WEST SUSSEX COUNTY COUNCIL CONSULTATION

TO:	Arun District Council FAO: Andrew Wood
FROM:	WSCC - Highways Authority
DATE:	10 October 2019
LOCATION:	Merry England Nursery Dappers Lane Littlehampton BN16 4EN
SUBJECT:	A/132/19/DOC Approval of details reserved by condition imposed under ref A/142/16/OUT relating to Condition Nos 4 - surface water drainage, 6 - flows to watercourses, 7 - SuDs system, maintenance of any watercourse, 11 - Construction Management Plan, 12 - road safety audit, 14 - ecological, 17 - tree protection and 21 contamination.
DATE OF SITE VISIT:	N/A
RECOMMENDATION:	Advice
S106 CONTRIBUTION TOTAL:	N/A

CGS civils Consulting Civil Engineers			
CLIENT GD GROUP			
ARCHITECT CITYZEN			
JOB TITLE MERRY ENGLAND ANGMERING			
DRAWING TITLE CONSTRUCTION DETAILS SHEET 1 OF 2			
DRAWN LH	ENGINEER	CHECKED CS	APPROVED
DATE SEPT 2019		SCALE @ A1	1:20
JOB NO. C1249	STATUS P	DRAWING NO. 300	REV. P2

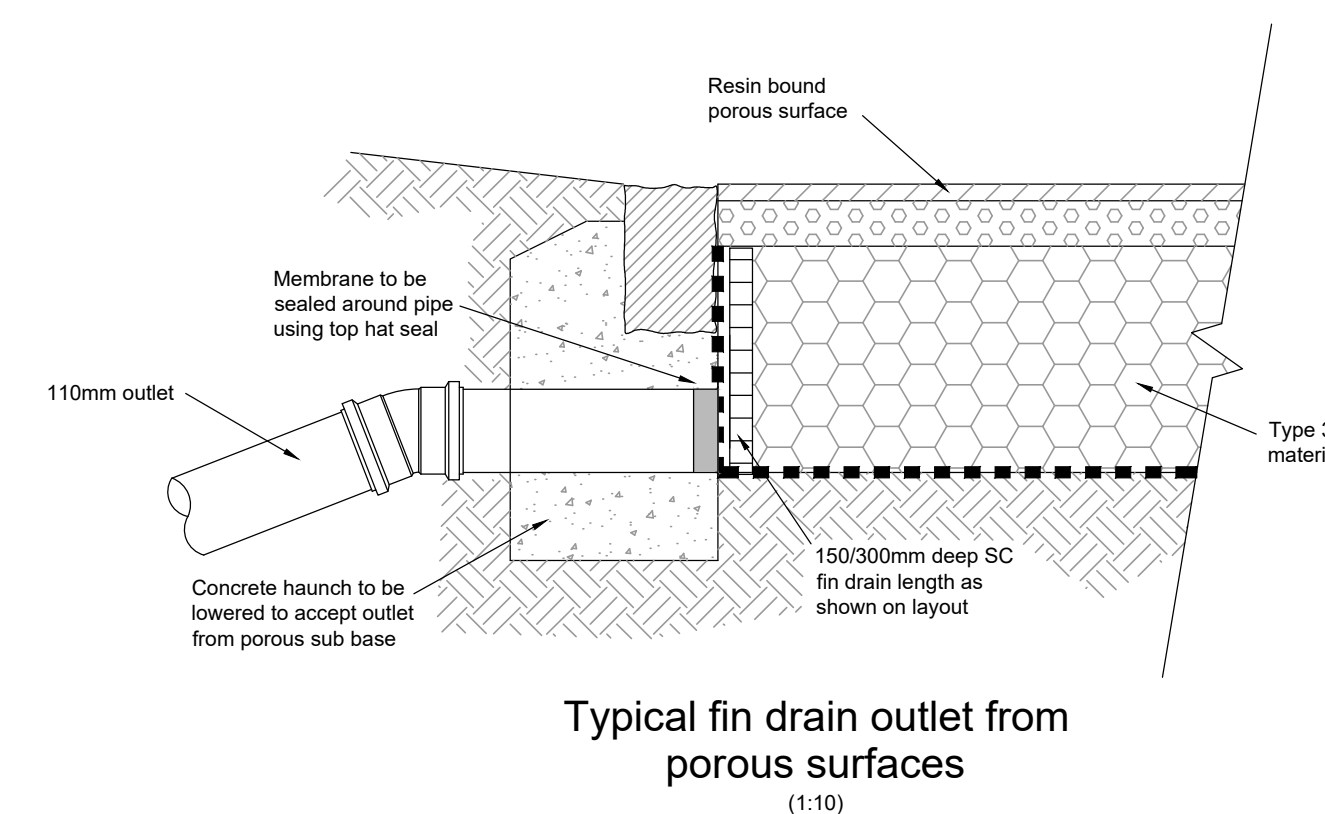
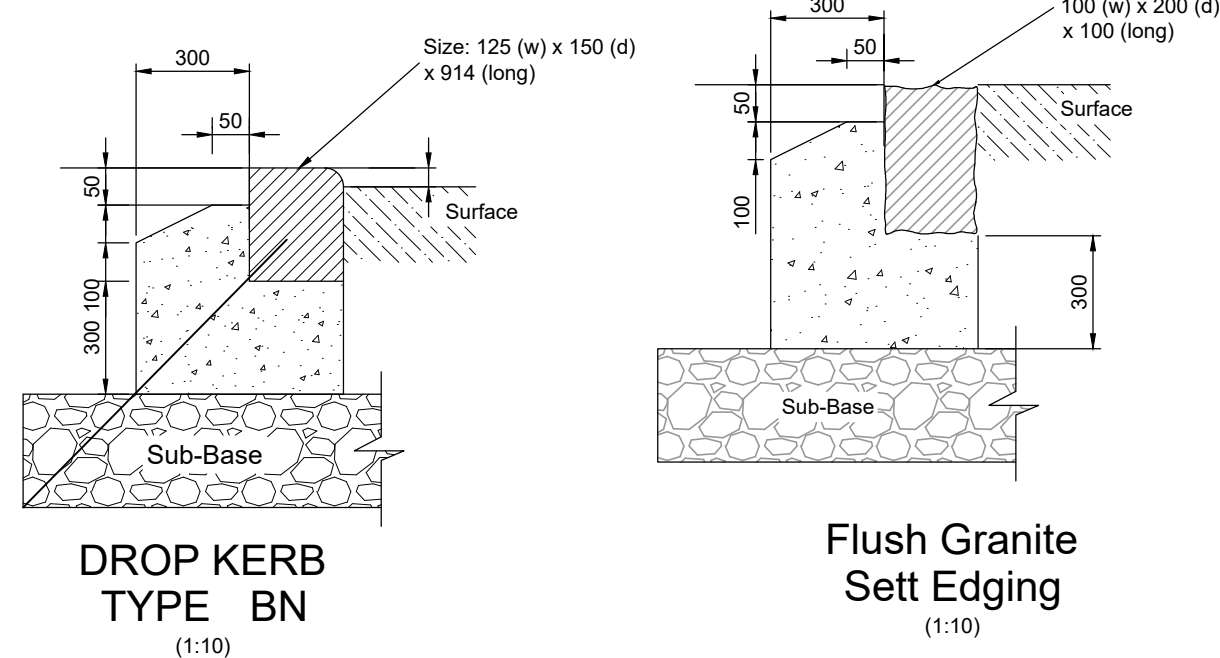
Condition 12- This relates to the Stage 1 RSA. This demonstrates visibility splays of 43 metres at the point of access onto Dappers Lane. In addition the footway connection has been demonstrated onto Dappers Lane with tactile paving providing the crossing points. The LHA are satisfied the condition can be discharged. The applicant is advised however that Technical Approval will be required as part of the Section 278 works for the implementation of the works.
